Please upload the revised attached plans from the applicant onto Ocella for BN/85/19/DOC. I have attached the Action Sheet.

Subject: RE: BN/85/19/DOC - The Lillies
Importance: High

I have received the email below from the applicant for BN/85/19/DOC at the Lillies, Yapton Road in Barnham.

## TYPICAL MANHOLE DETAIL TYPE B

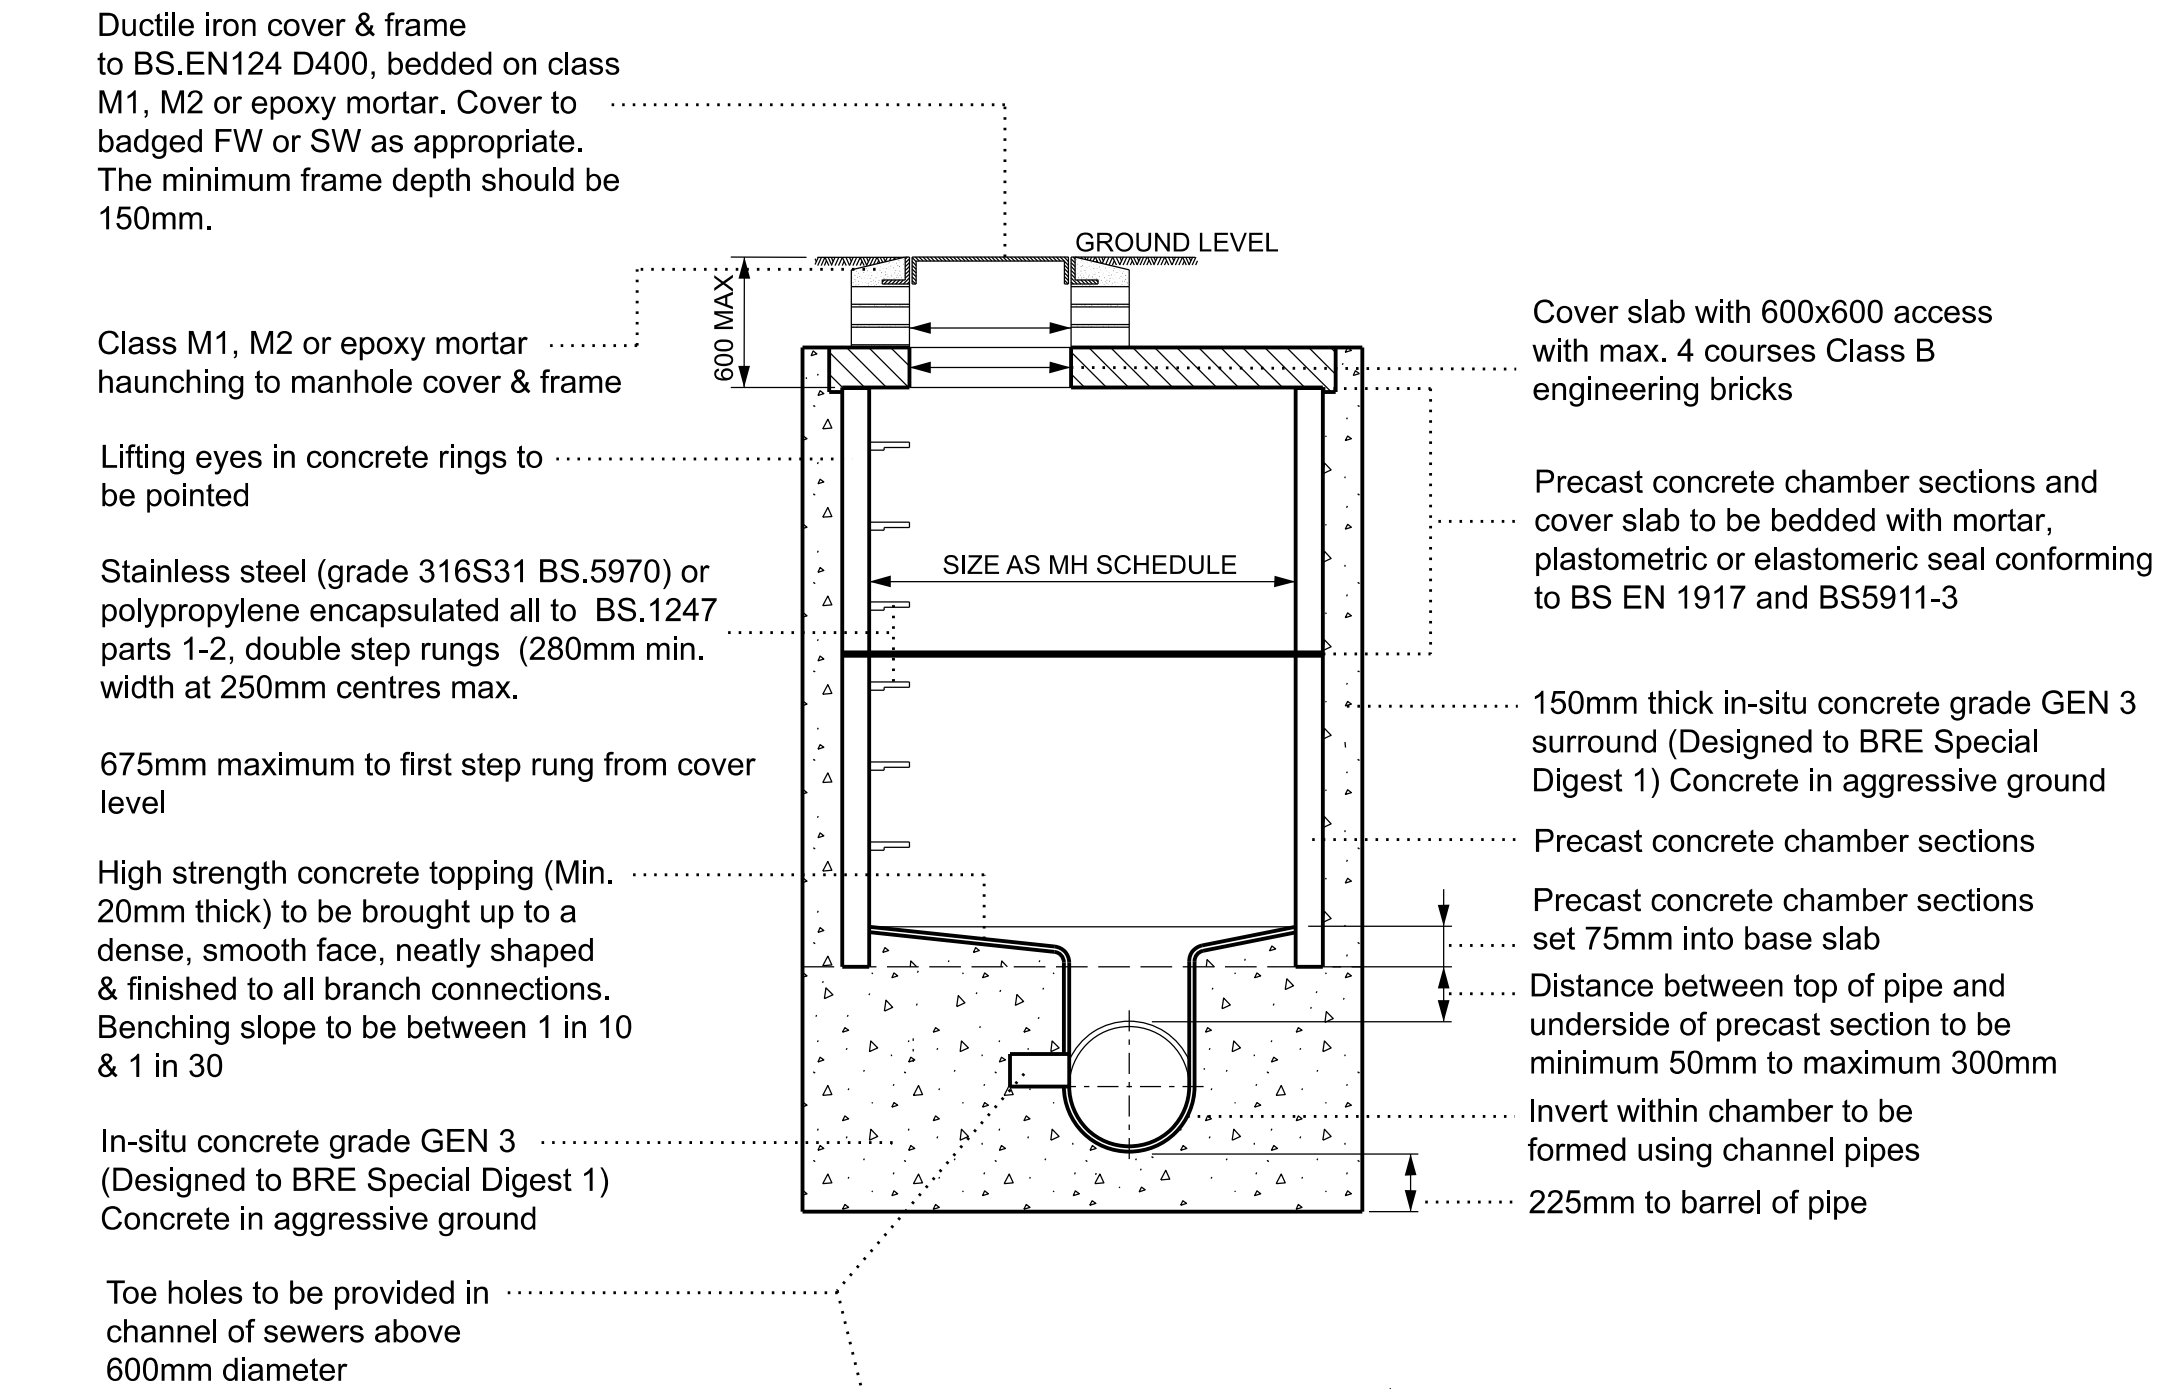
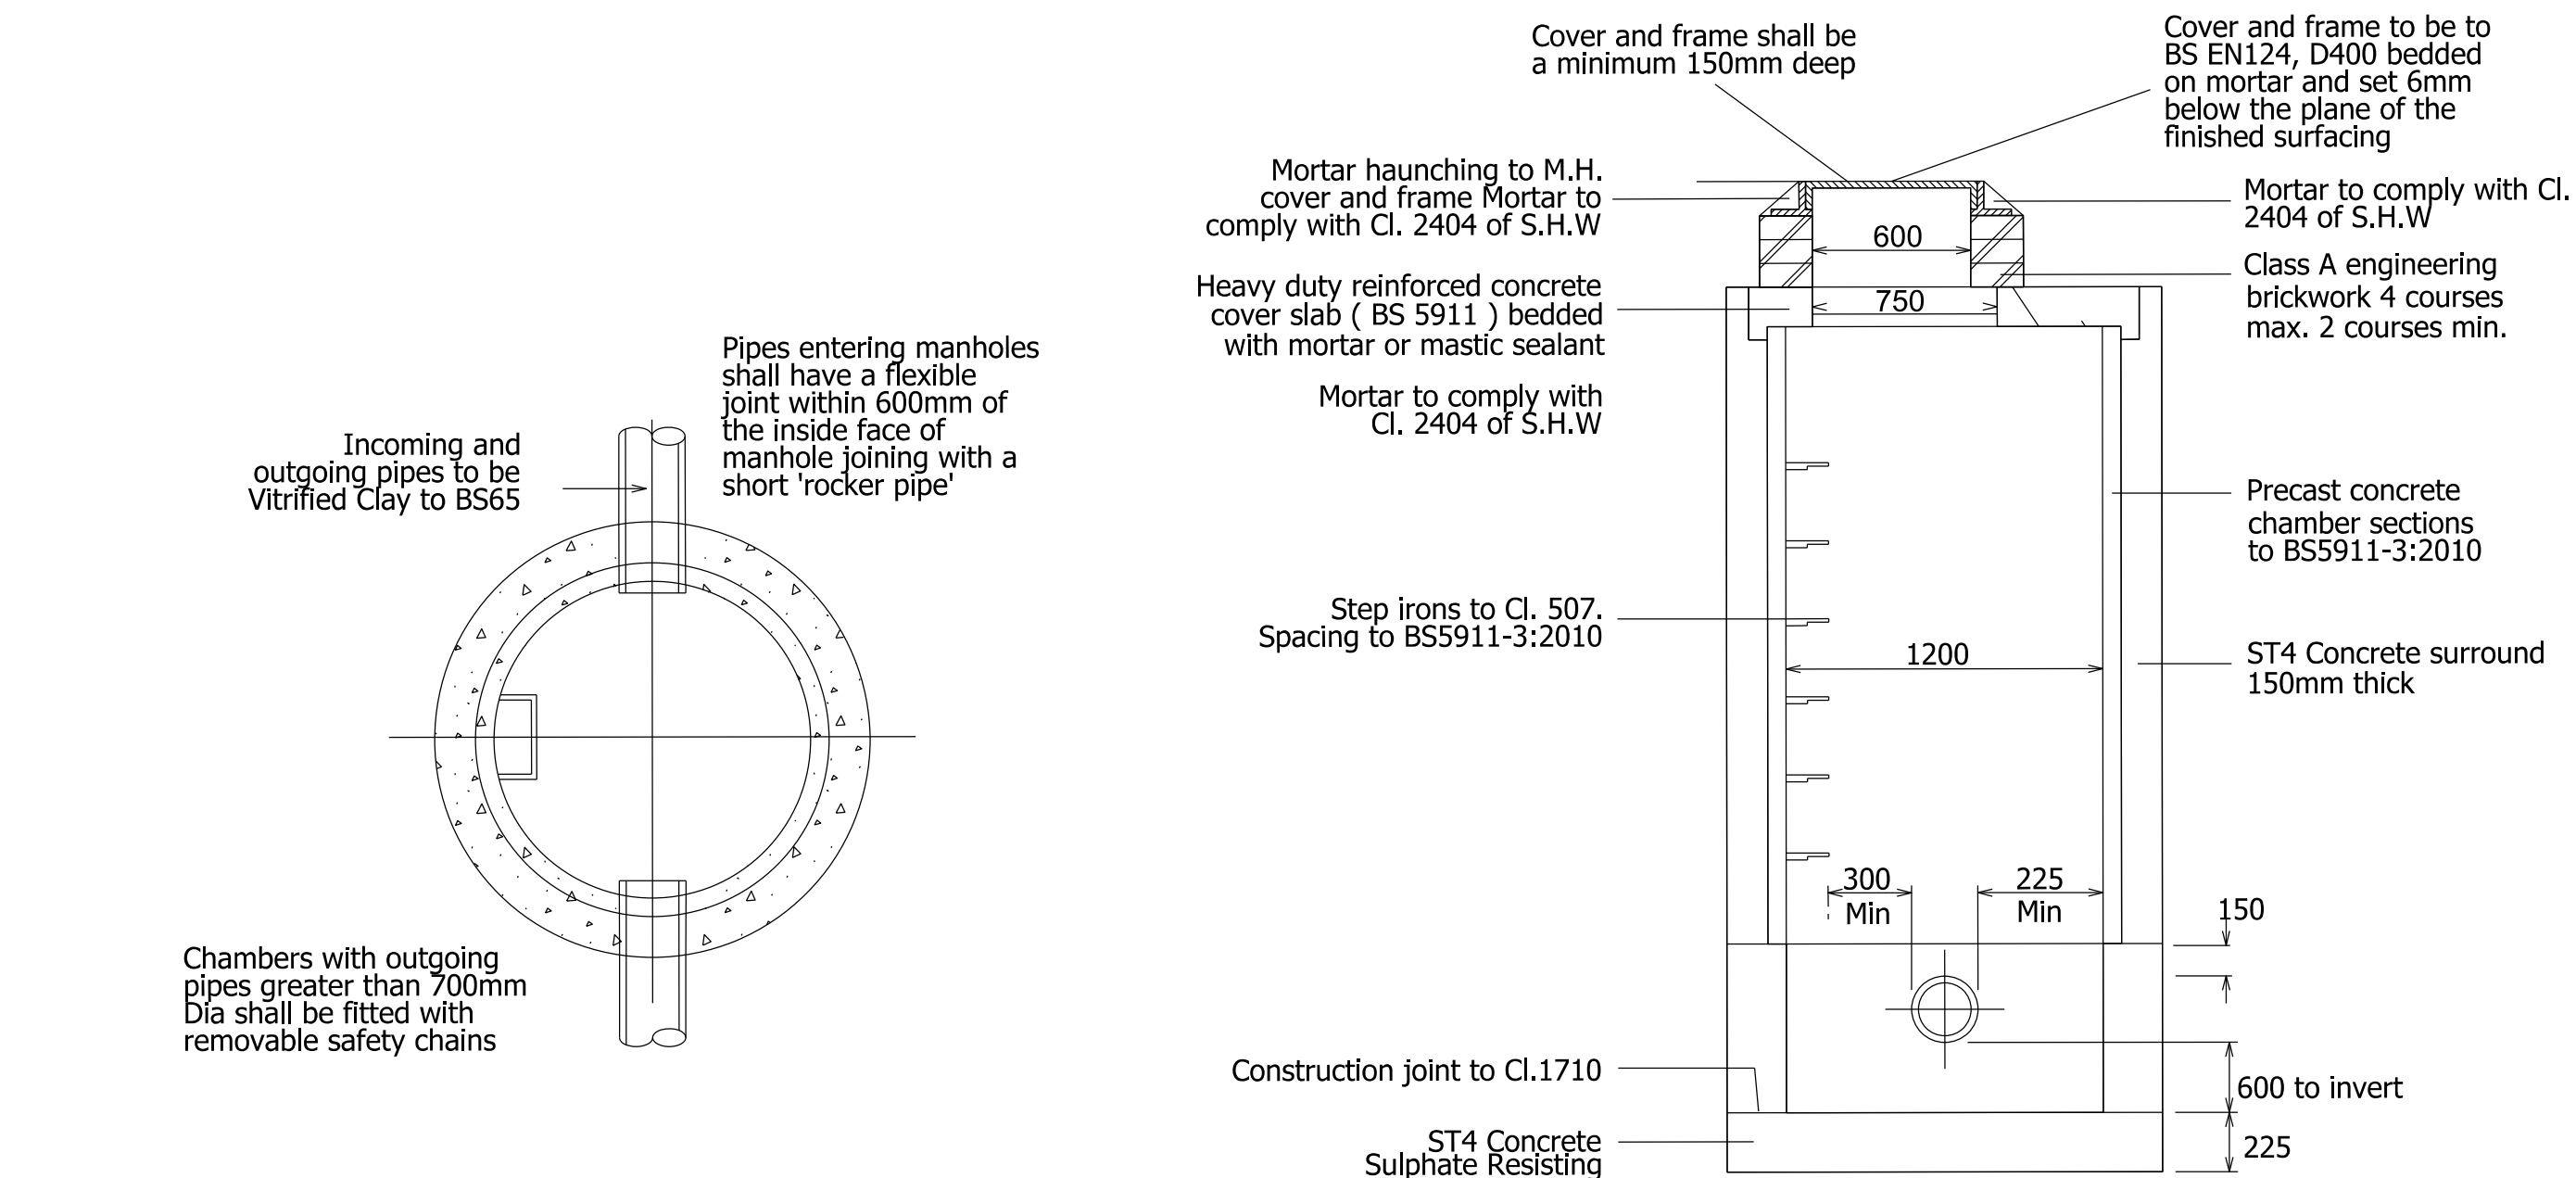
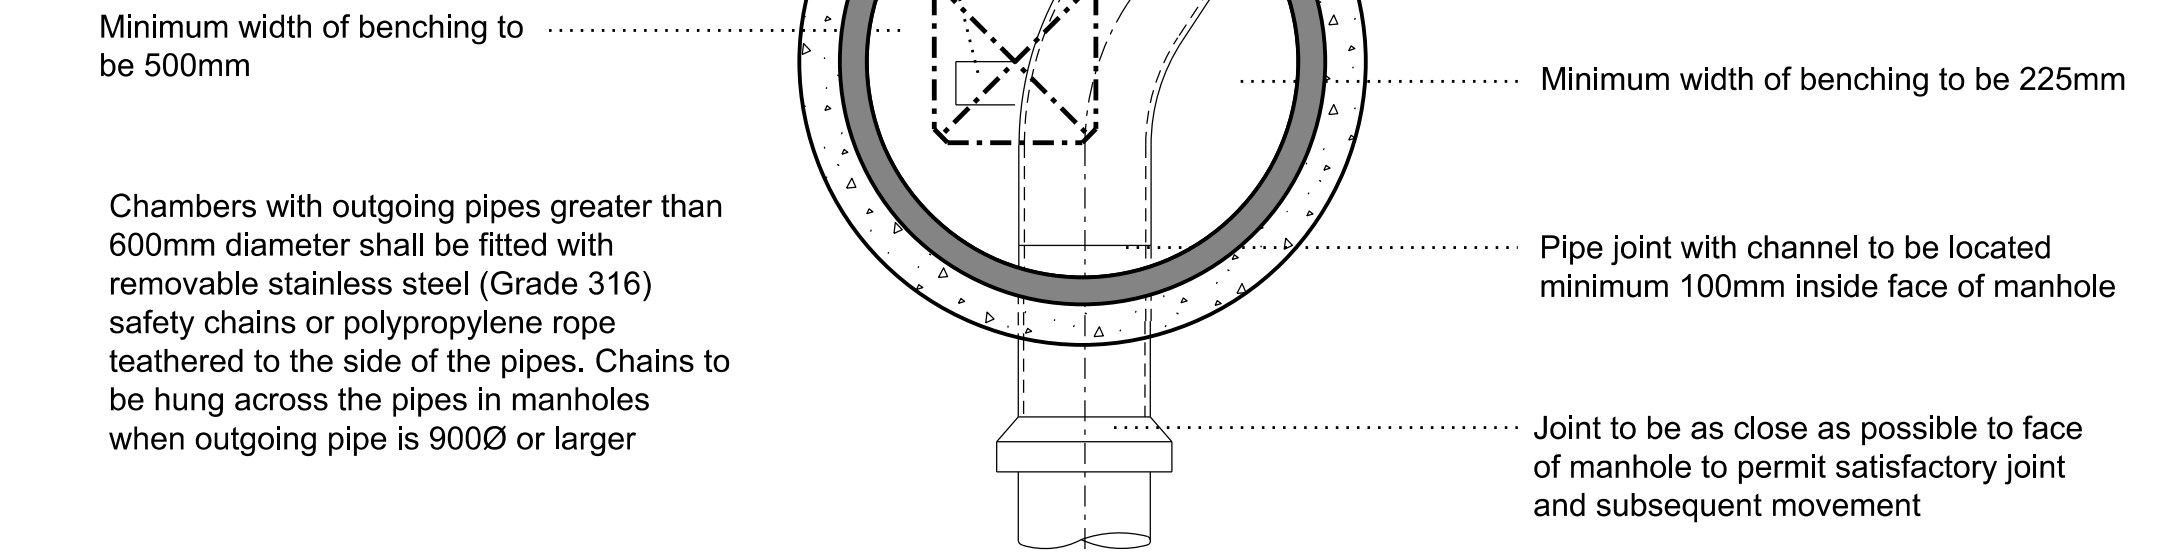
14. Add note 'All pipes to be connected at soffit to soffit level'. Added
15. Provide manhole construction details for all manholes in the highway. Drawing included

16. Provide pipe bedding details ie. class S and class Z. Drawing included
17. Provide road gully construction details. Drawing included
18. Specify pipe materials. Drawing included
